Your Ref :
Our Ref : EG/35/14/NMA

Application for a non-material amendment following a grant of planning permission EG/29/13 -
amending garage roof of plot 18 to be grey tile
Former Brooks Nursery, Eastergate, ,

Scale	1:500 @ A2	Drawn	DGP	Checked	DGP
Date	August 2012	File	P706-Layout	Drawing Status	
Drg.No.	P706/102	Rev.	H	Planning

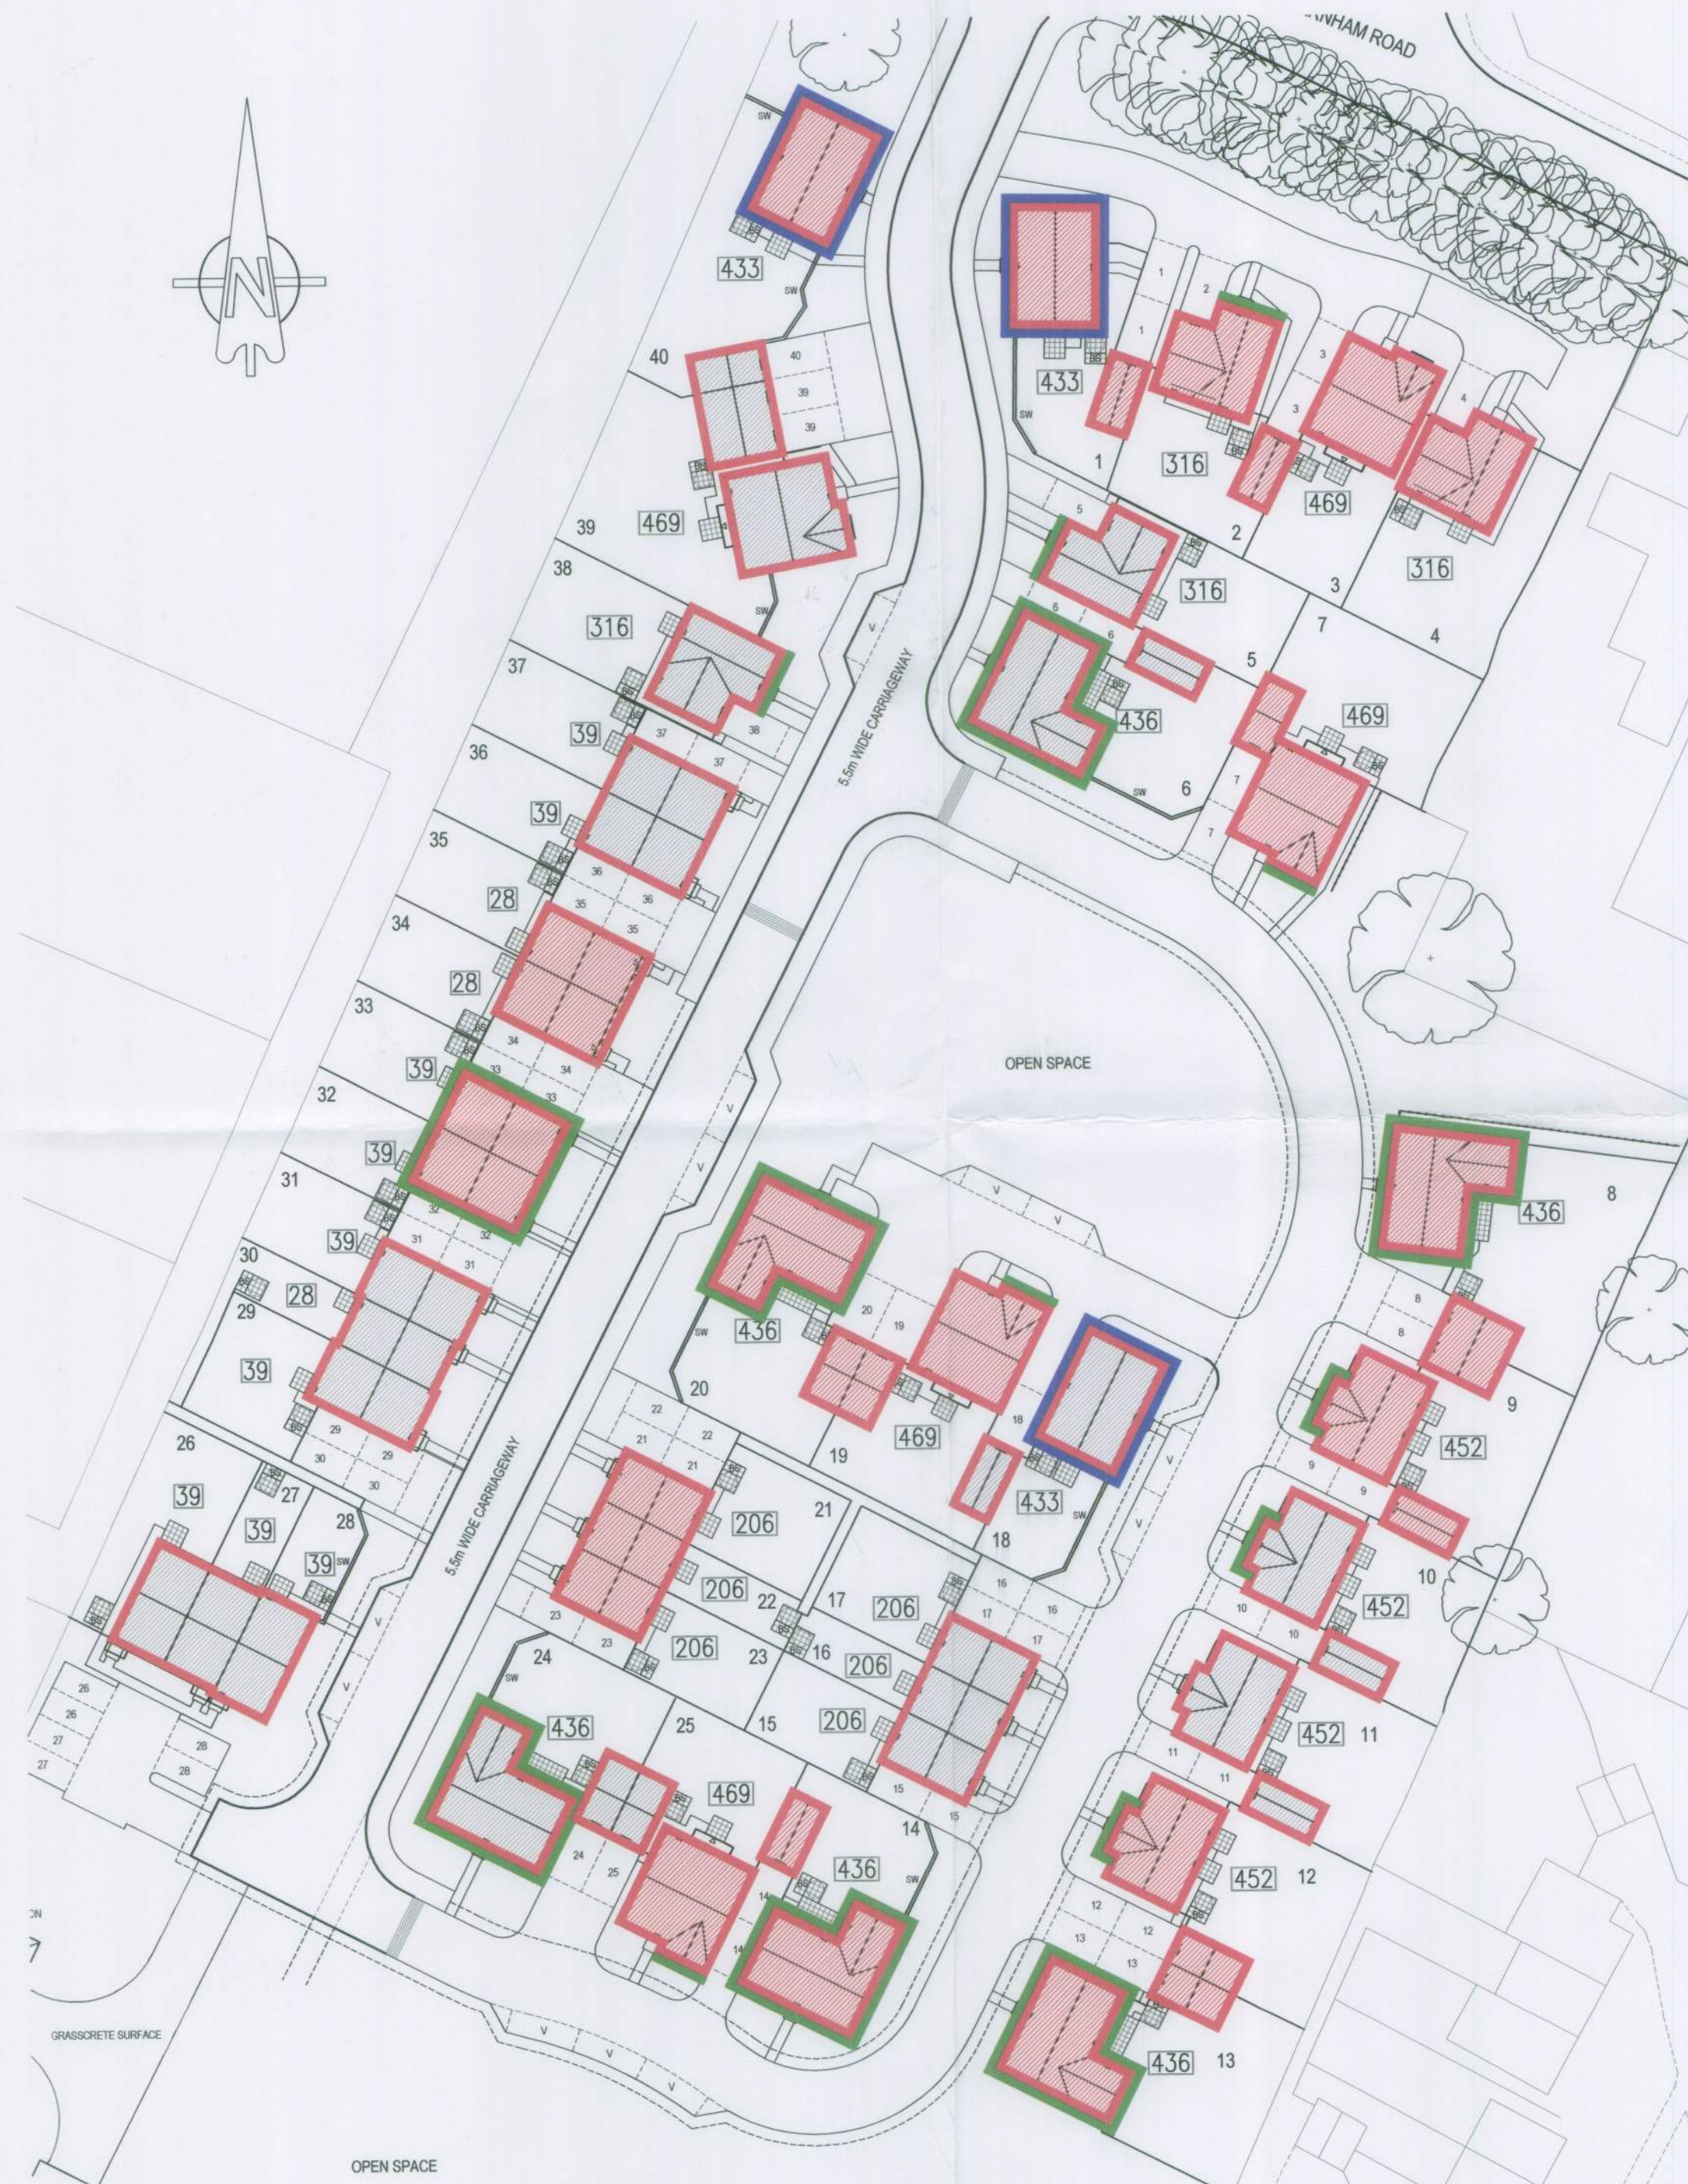
I refer to your recent application for a Non Material Minor Amendment. From the information submitted it is accepted that the proposed change to the roof material for the garage serving plot 18 from a red tiled finish to a grey tiled finish is considered to be a minor amendment to the approved scheme

Please note that Drawing No. P706/102 Revision H (Materials Layout) replaces Drawing No. P706/102 Revision D (Materials Layout).
